RE: Graythwaite Rehabilitation Centre

In response to submissions

Yours faithfully,
nettletontribe

Site Plan
1:500 @A1
17.02.12
3717-DA-001
© copyright nettleton tribe partnership pty ltd

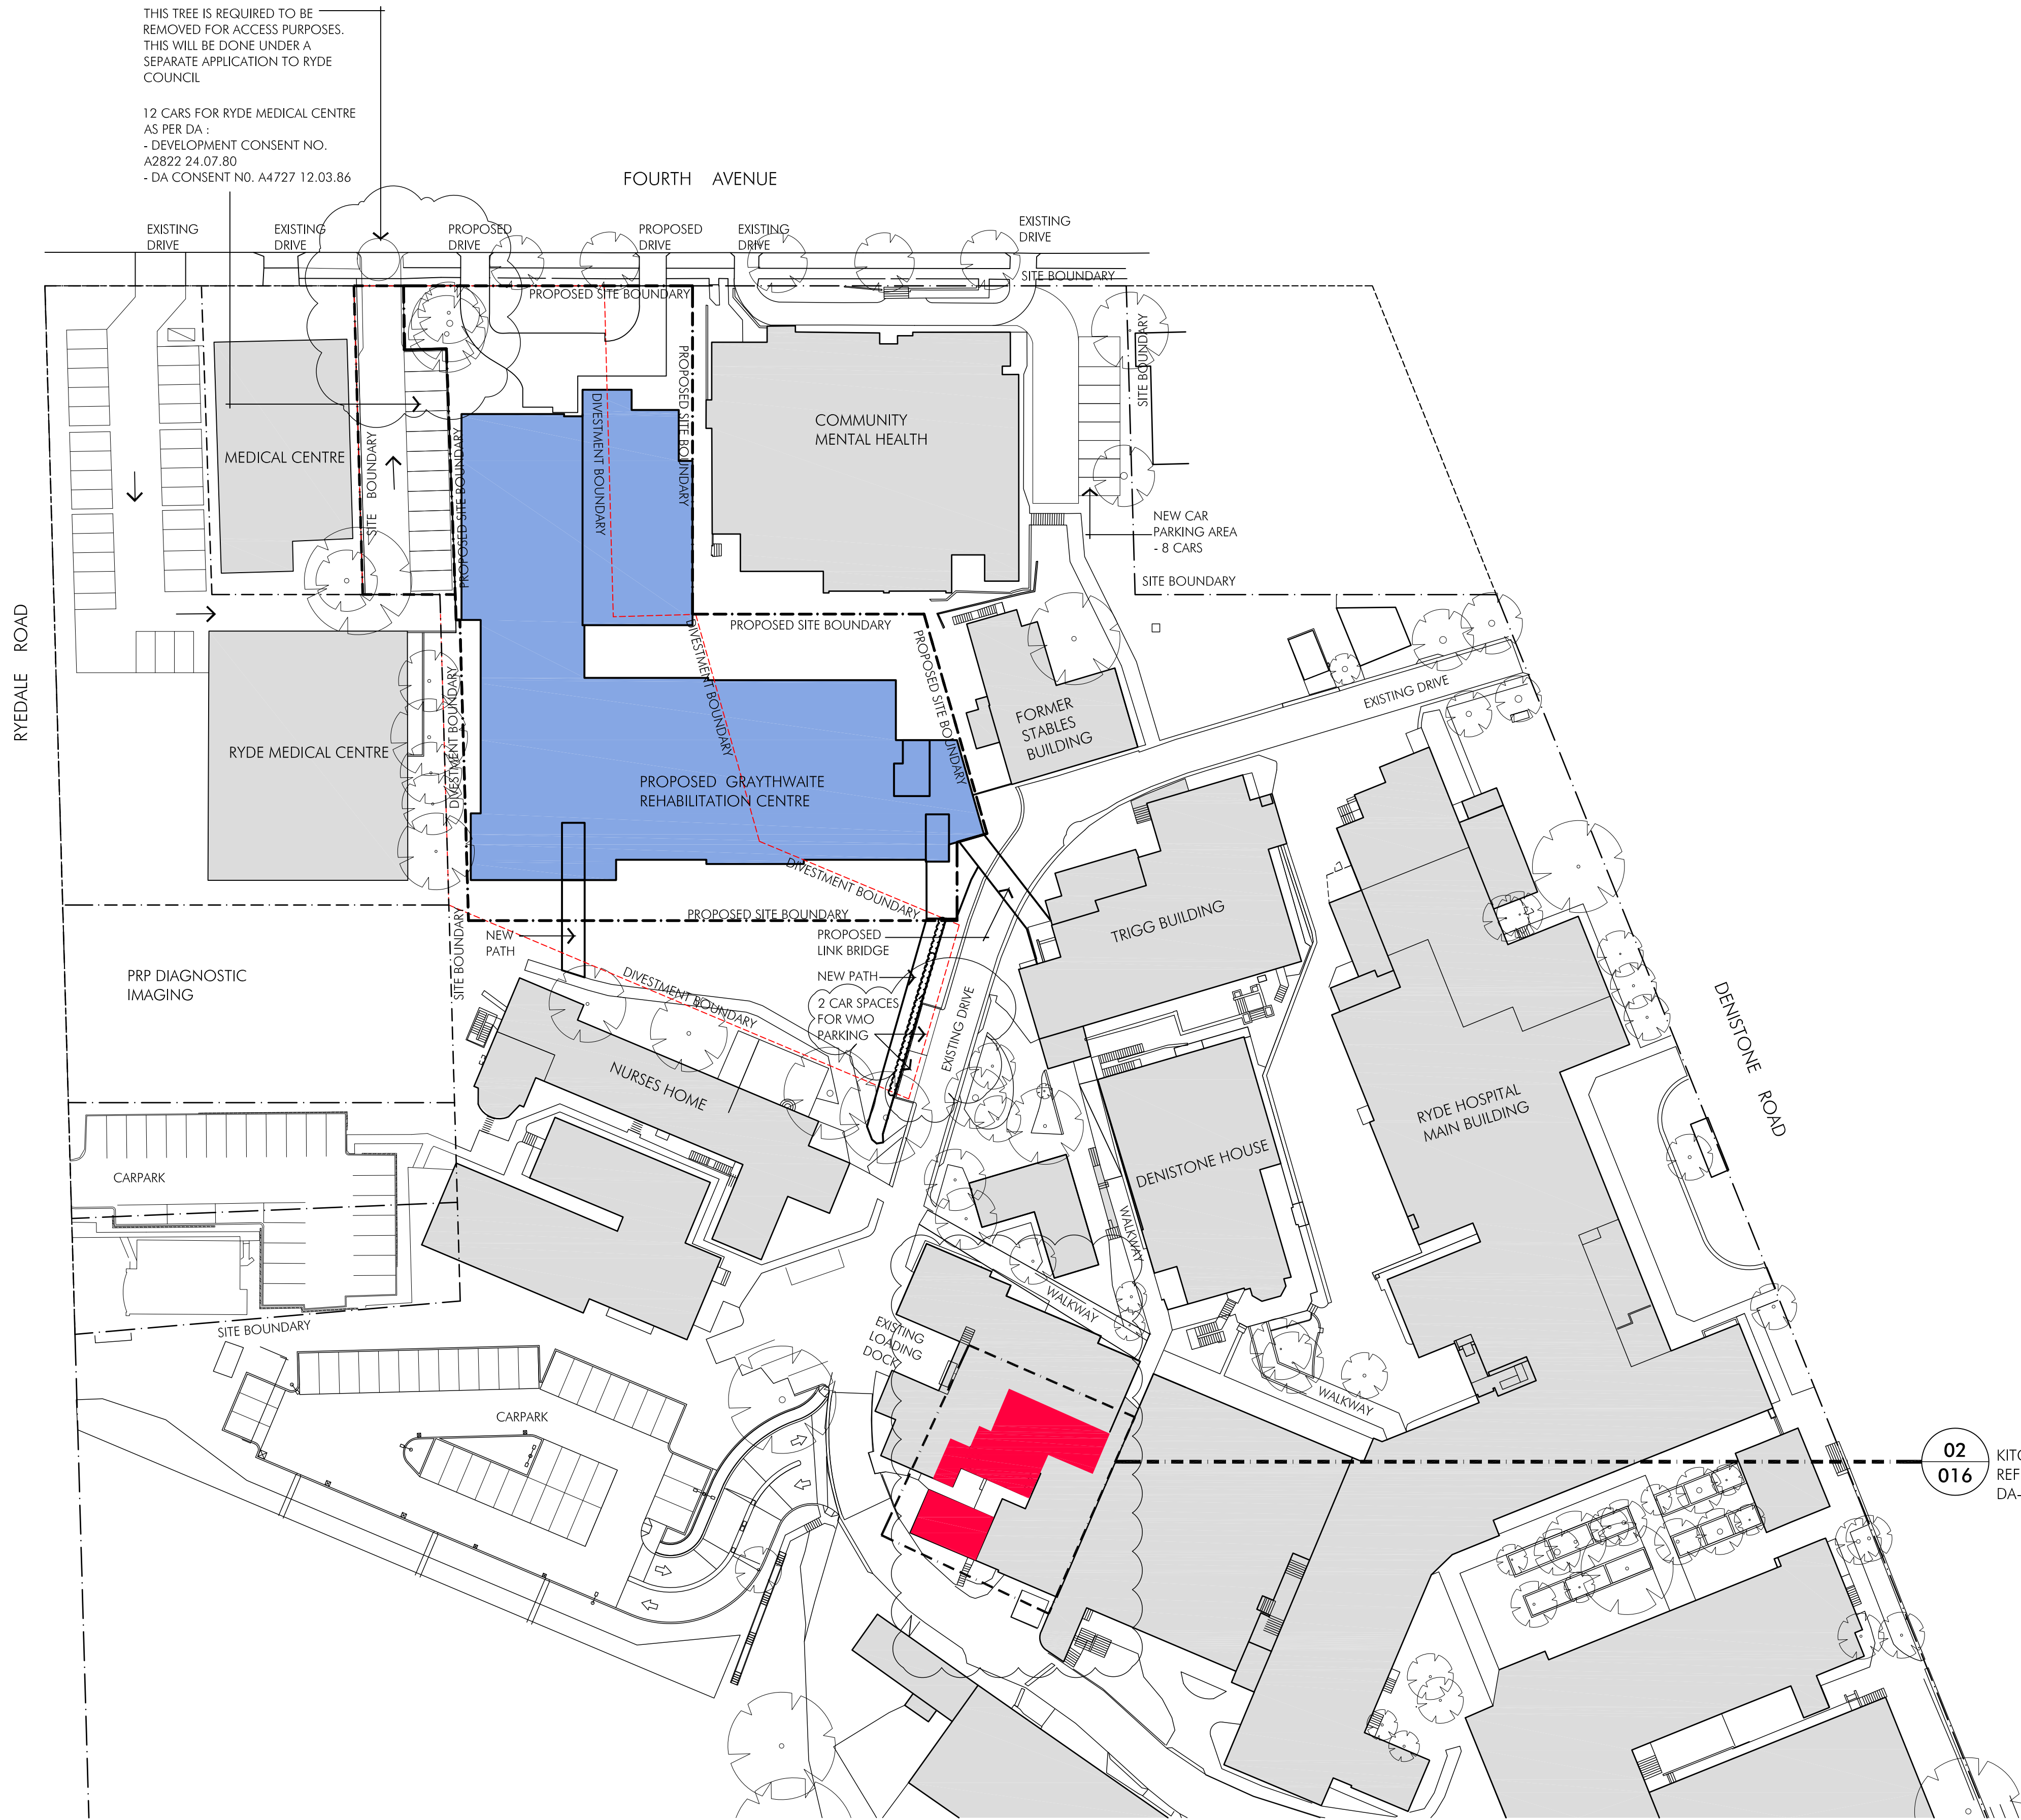
"Removal of Street Tree"

The removal of the tree has been sought to enable the new driveway access for the Ryde Medical Centre parking exit. The site frontage is relatively narrow to Fourth Ave. The existing driveway was proposed to be relocated west to allow room for the Brigade sprinkler booster assembly to be located directly on the street frontage.
